**Consultation Response from KC,
Highways Development Management**

2025/91151 The Chartist, 74, Commercial Road, Skelmanthorpe, Huddersfield, HD8 9DS

Reserved matters application pursuant to outline permission 2023/92551 for erection of residential development (4 dwellings) (within a Conservation Area)

Date Responded: 11-6-2025

SITE PLAN (NTS)

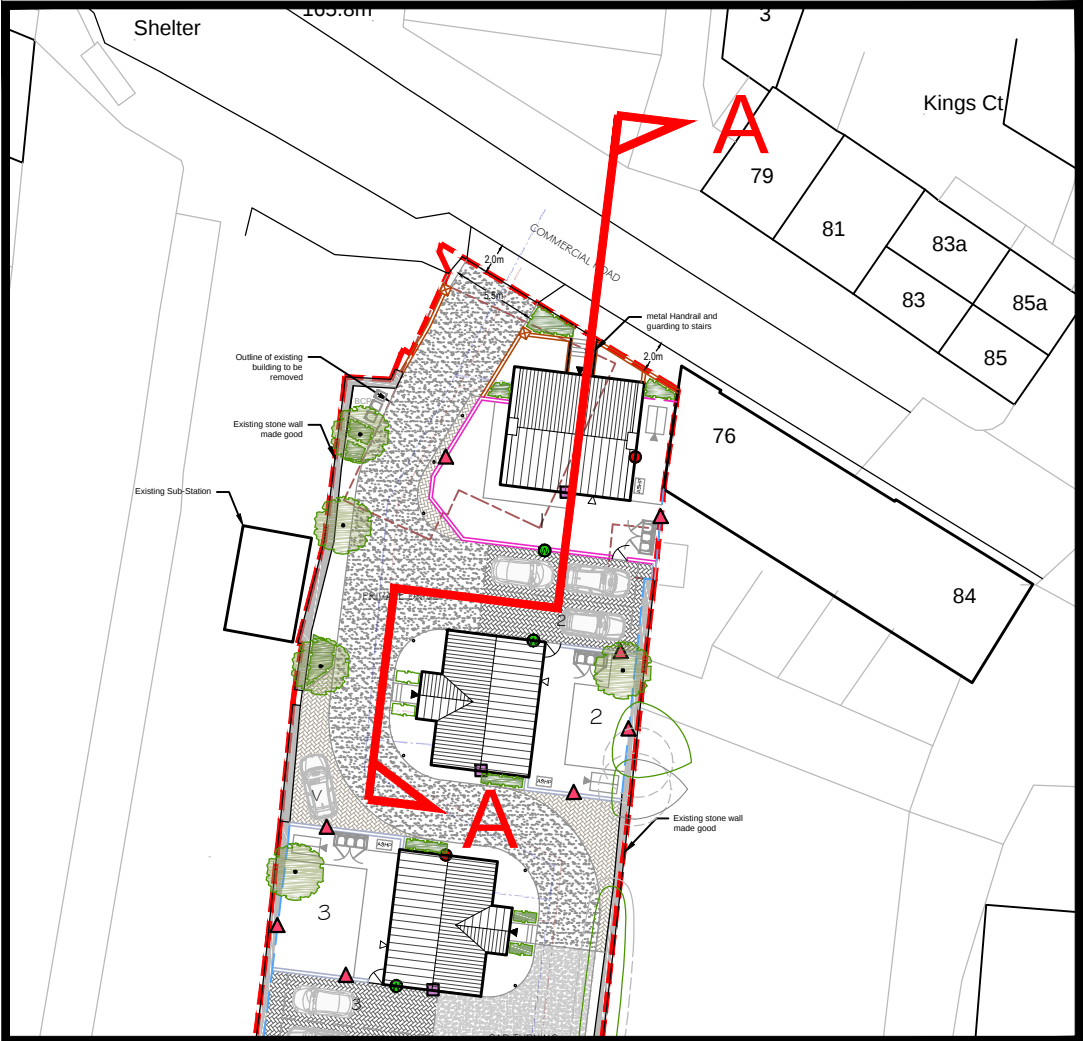
These proposals differ from the approved plan in that the width at the access is sufficiently wider than the proposals shown on the approved scheme. This is not considered necessary. The driveway should be shown to be 5.5m in width.

The 2.0m wide footway required by the 2023 permission to the site frontage is also not shown on the plans.
